Recommendation Report for Planning Permission for Works or Extension to a Dwelling

REF NO: EG/16/19/HH

LOCATION: 49 Warren Way
Barnham
PO22 0JX

PROPOSAL: Two storey extension

Site & Block Plan

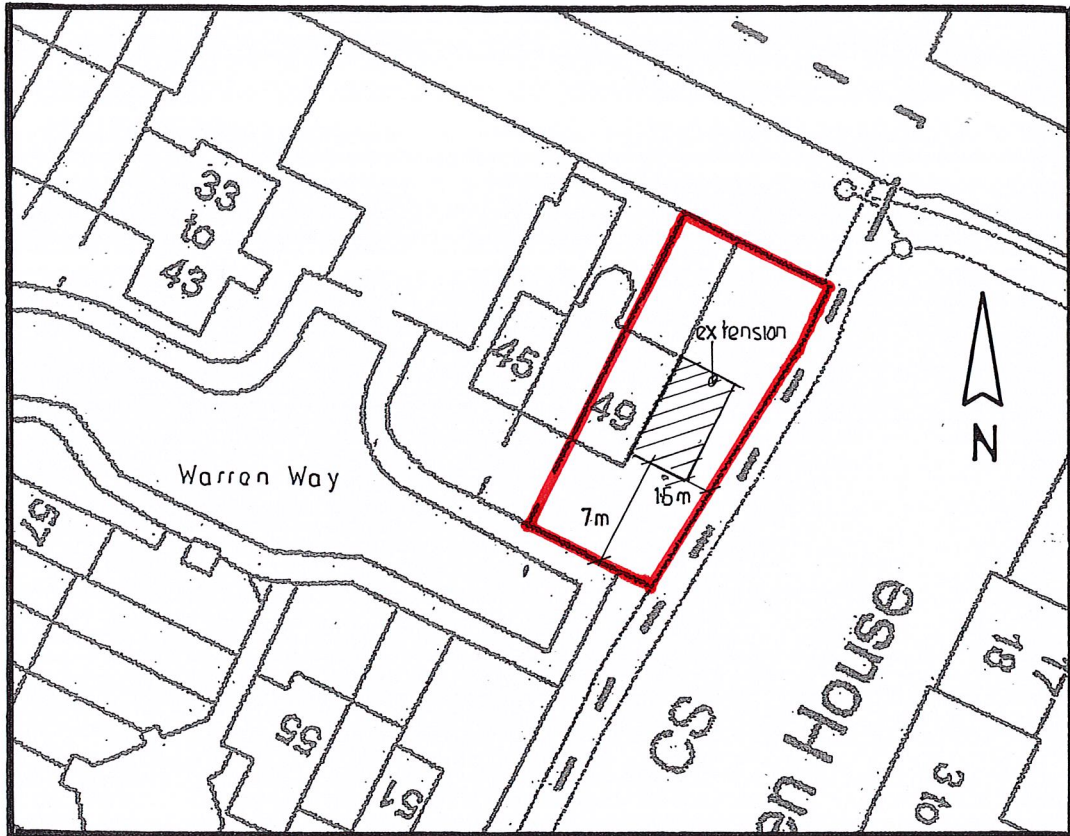
Environment Agency - We object to this application as it is within flood zone 3 and is at risk of fluvial flooding. The extension is also proposed 1.6m from a main river and could increase flood risk elsewhere being built that close to the main river. The proximity to the river could compromise the structural stability of both the bank and proposed extension. A permit should also be obtained for any activities within 8m of a main river.

The proposal is located to the eastern side of the dwelling and as result of its location, it is situated only 1.6m from the bank of a main river. Due to the siting of the development it could increase flood risk elsewhere as a result of its position being built so close to the river. Due to its siting again this has the potential to compromise the structural stability of the both the bank and the extension. This conflicts with WDM2 (b) in such that there is potential that the development could result in the bank and extension being unsafe and result in increasing flood risk elsewhere.

- 1 Due to the position of the proposed extension it is considered that the development will increase flood risk elsewhere as a result of it being constructed 1.6m from the main river. Due to its siting again this has the potential to compromise the structural stability of the both the bank and the extension. As such the development conflicts with WDM2 of the Arun Local Plan and ES1 of the Barnham and Eastergate Neighbourhood Plan.

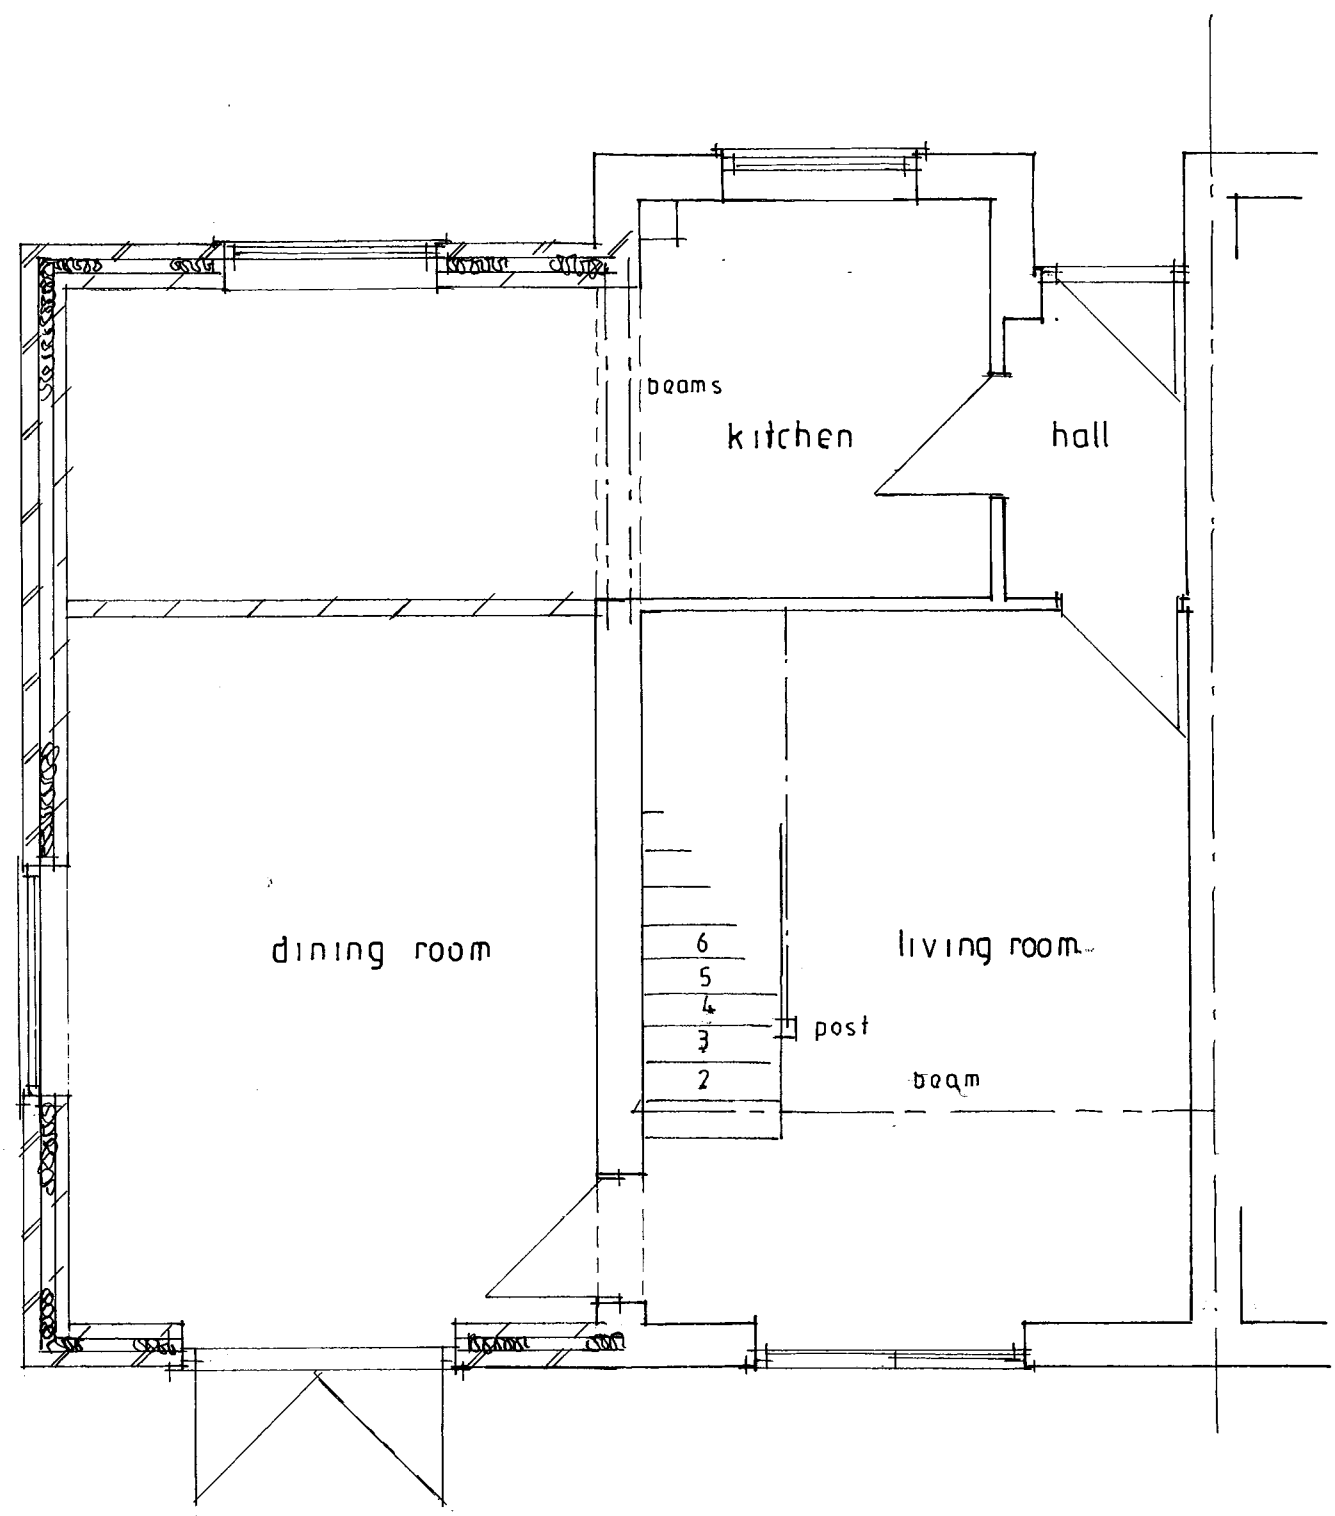
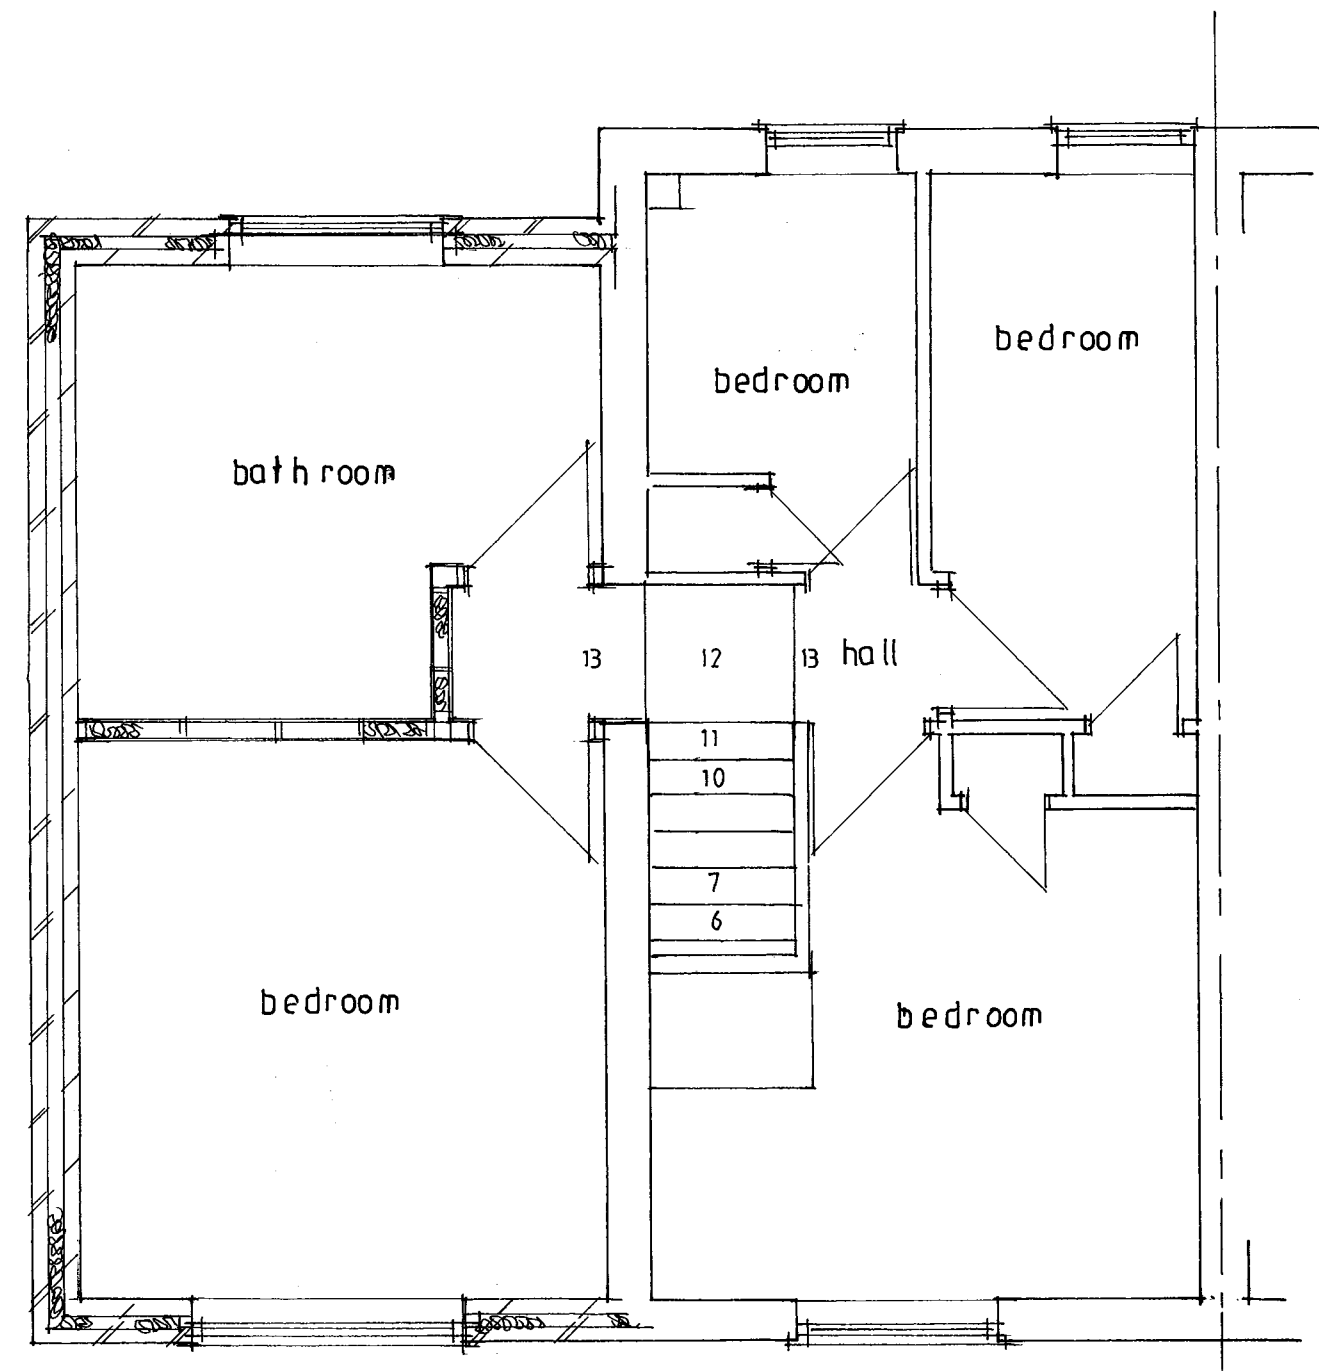
The proposed two storey side extension will have a width of 3.75m. This retains 1.6m to the eastern boundary. Its height is just below that of the ridge height of the host dwelling. The extension runs along

With no neighbours to the north or east elevation, the extension is not considered to appear overbearing or overshadowing upon neighbouring amenity. There is a ground floor window located to the east elevation however with no neighbouring properties it is also not deemed to give rise to any adverse overlooking.

There are 2 additional windows to the rear, however due to the siting of the windows and extension, they are not considered to provide any adverse overlooking as a result. Two additional windows to the front will overlook the street scene.

Proposed Elevations & Roof Plan

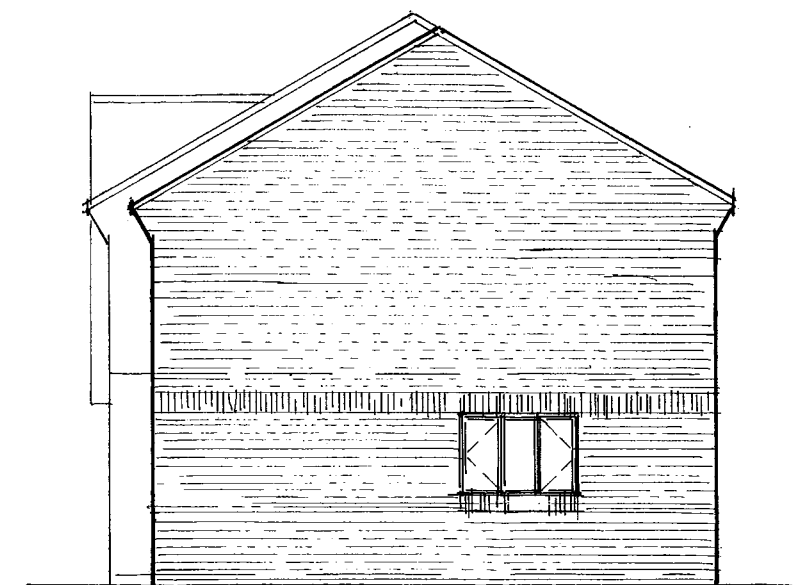
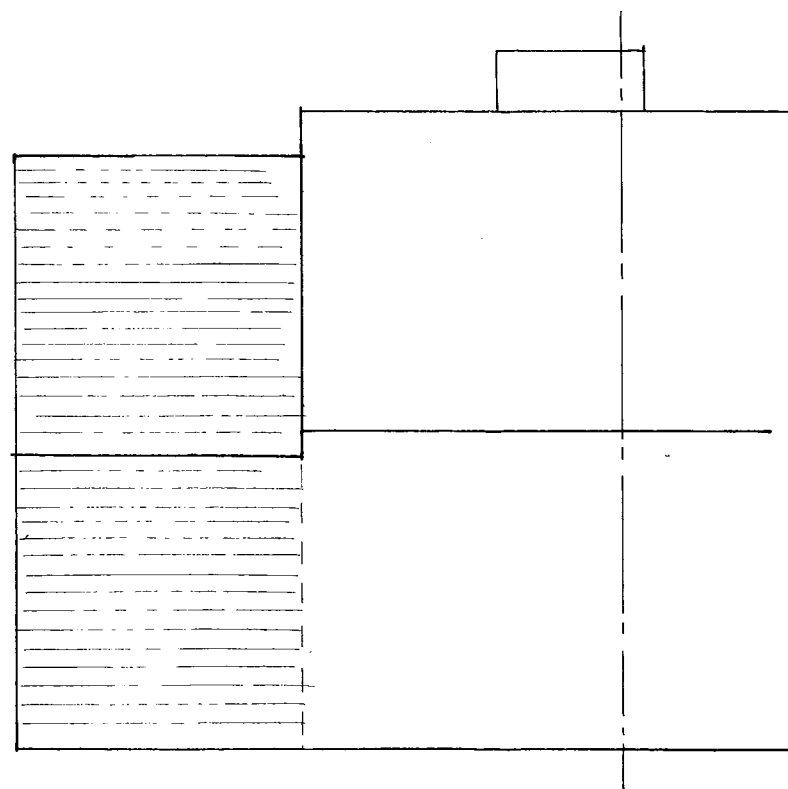
The proposal seeks to construct a two storey side extension and is therefore visible from the street scene. It is sited around 0.5m behind that of the principle elevation and as such does not appear unduly dominant. The dwelling is located to the rear corner of cul de sac and as such views are limited.

The materials proposed will match that of the existing dwelling and as a result the extension appears well integrated. Whilst the neighbouring properties are of a similar style and design due to the siting of the development it is not considered to adversely impact upon the spatial pattern or character of the street scene and accord with DDM1 and DDM4 of the Arun Local Plan.
